# CITY OF ALBUQUERQUE

**Re: Musket Development**  
**1615 8<sup>th</sup> Street NW**  
**Request Permanent C.O. - Accepted**  
**Engineer's Stamp dated: 10-22-15 (J14D175)**  
**Certification dated: 2-23-16**

RE: **Musket Development**  
**Grading and Drainage Plan**  
**Engineers Stamp Date 10/22/15 (J14D175)**

**RE: Musket Development  
1615 8<sup>th</sup> St NW  
Grading and Drainage Plan  
Engineers Stamp Date 10/6/15 (J14D175)**

MUSKET DEVELOPMENT 1615 8th STREET NW	DRAWN BY pm
	GRADING AND DRAINAGE PLAN	DATE 5-19-15
	TIERRA WEST, LLC 5571 MIDWAY PARK PL. NE ALBUQUERQUE, NEW MEXICO 87109 (505) 858-3100 www.tierrawestllc.com	DRAWING 2015014-GR
		SHEET # GR-1
		JOB # 2015014

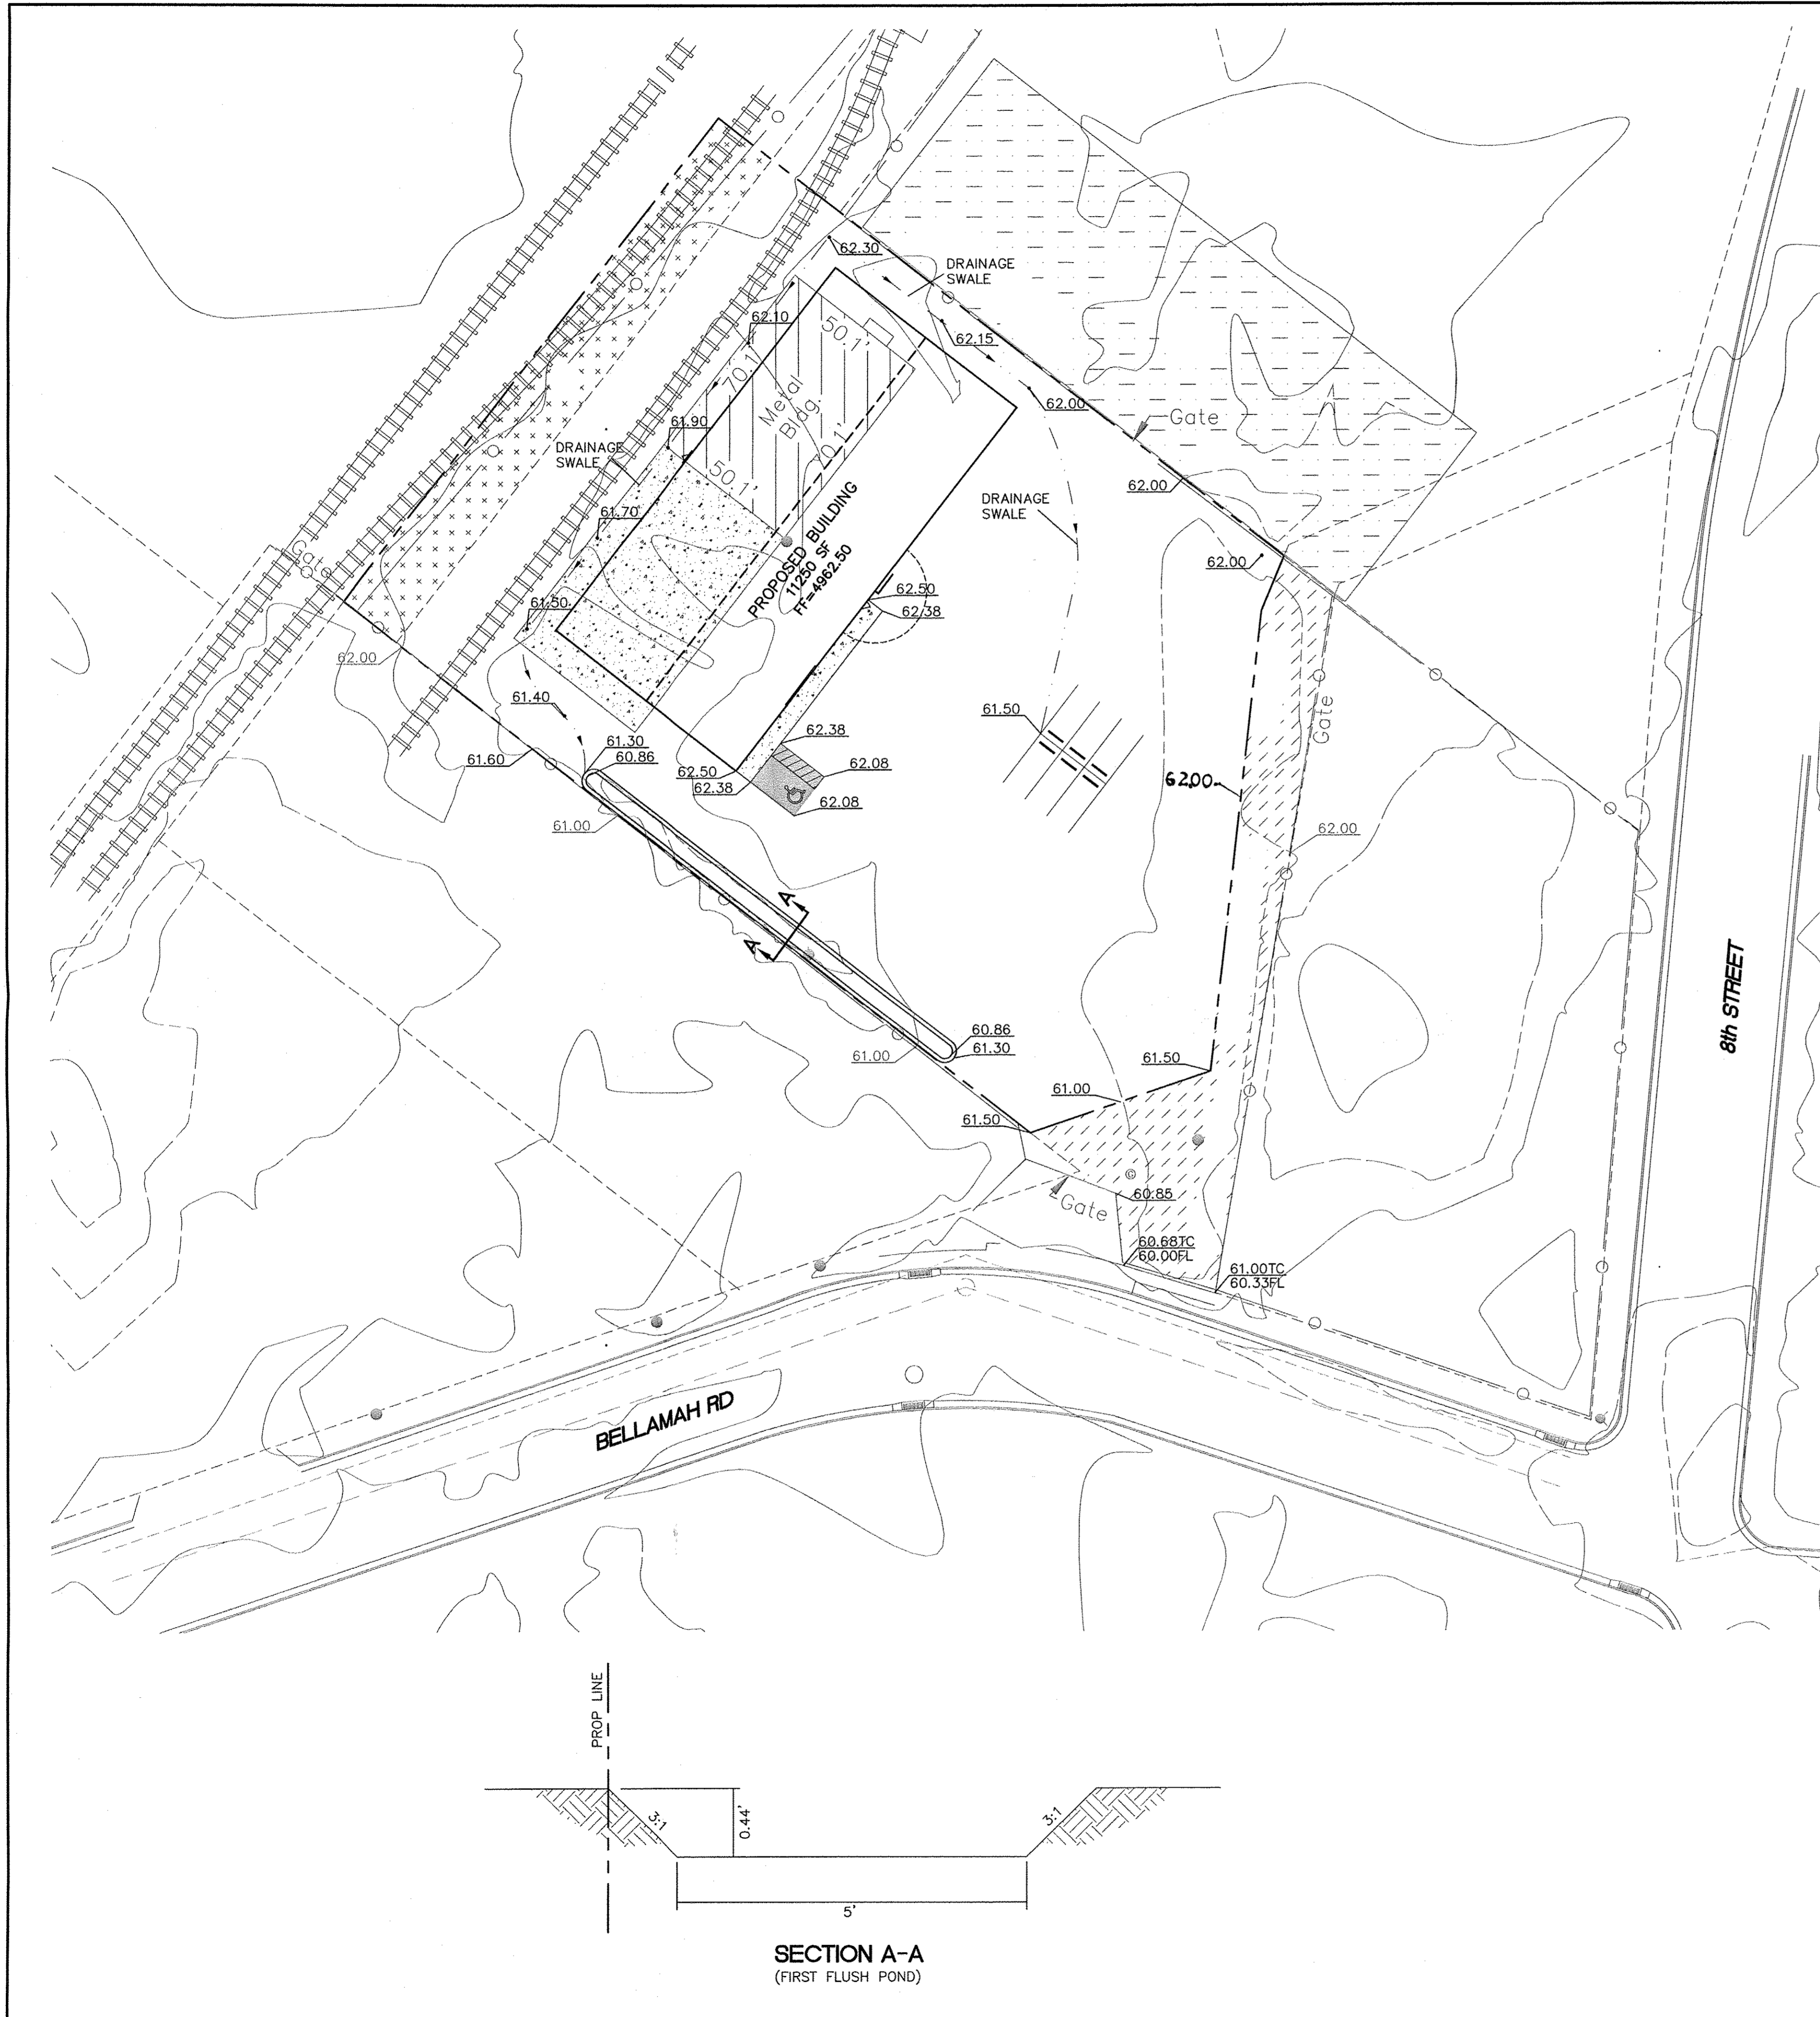
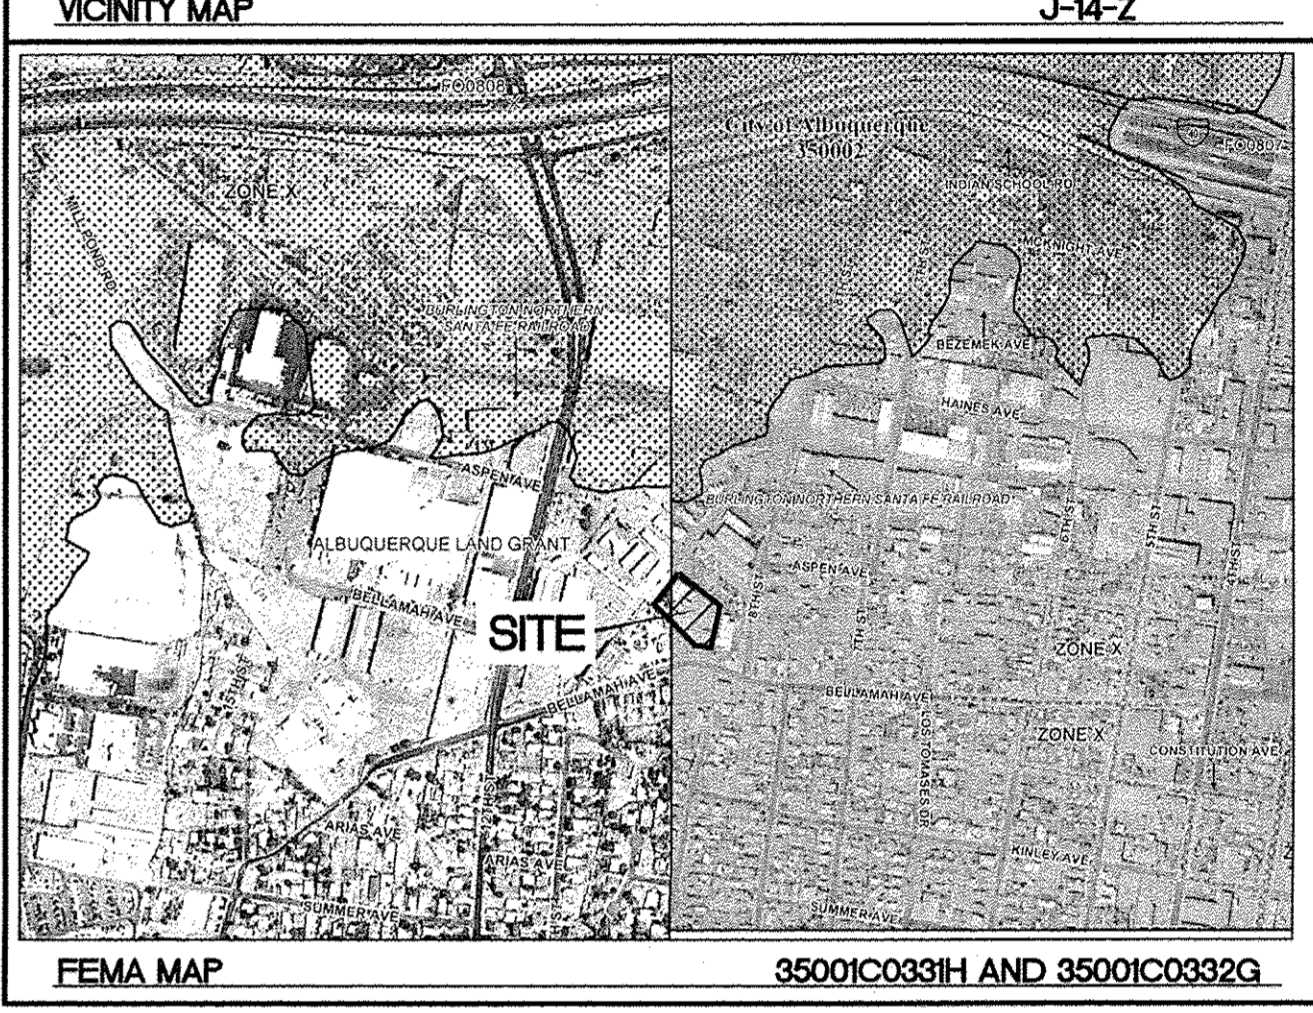
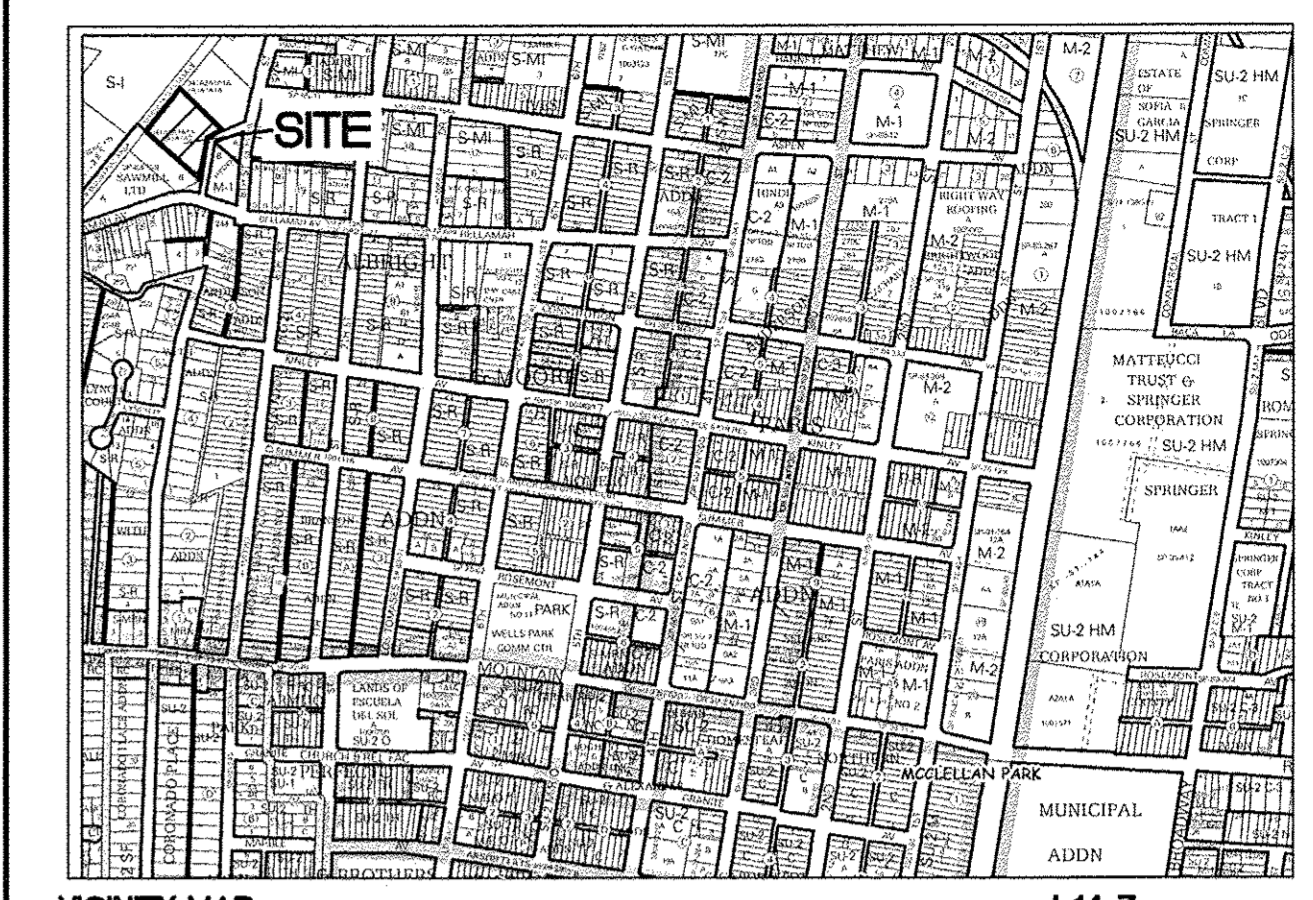
- Provide how the First Flush Pond in section A-A will drain to the east and west. It appears this pond will overflow at the east end which has a top of curb at 61.3 and the west end top of curb is 62.10.

- Flows from the south side roof and paving around the building need to be directed toward the first flush pond.
- Is the swale at the rear of the building continuous? If the swale is continuous how will access to the train car be addressed?

- Provide new calculations for the impervious areas.
- Provide pond bottom and water surface elevation.
- Provide an emergency over flow for the pond to the north of the building, directing flows toward the front of the building.

- Does the 8"cmp provide enough capacity for the flows entering the pond?
- Provide if the railroad tracks has an existing easement. If so, does the owner have approval for the pond in this location with the two 8" pipes under the tracks?

**Response: The first flush/retention pond will overflow to the east. The revised grades now provide for the elevation at the east end of the pond to be 61.0 and the elevation of the pond at the west end to be 61.3**

2. Flows from the south side roof and paving around the building need to be directed toward the first flush pond.  
**Response: The swale in the main parking field has been revised to direct these flows to the first flush/retention pond.**

3. Is the swale at the rear of the building continuous? If the swale is continuous how will access to the train car be addressed?  
**Response: The swale is continuous. Access to train cars is provided near the south end of the rail spur.**

4. Provide new calculations for the impervious areas.  
**Response: Provided**
5. Provide pond bottom and water surface elevations.  
**Response: Provided**

6. Provide an emergency over flow for the pond to the north of the building, directing flows toward the front of the building.  
**Response: The pond north of the building was eliminated to avoid a timely process for securing an easement from the owner of the easement, NMDOT.**

7. Does the 8" cmp provide enough capacity for the flows entering the pond?  
**Response: The 8" cmp's are no longer required due to the elimination of the pond.**

**Response: The railroad tracks are in an easement on property owned by Musket. The process for securing a drainage easement from the NMDOT was proving to be time prohibitive so the pond was eliminated and the required volume place in the enlarged pond along the south property line.**
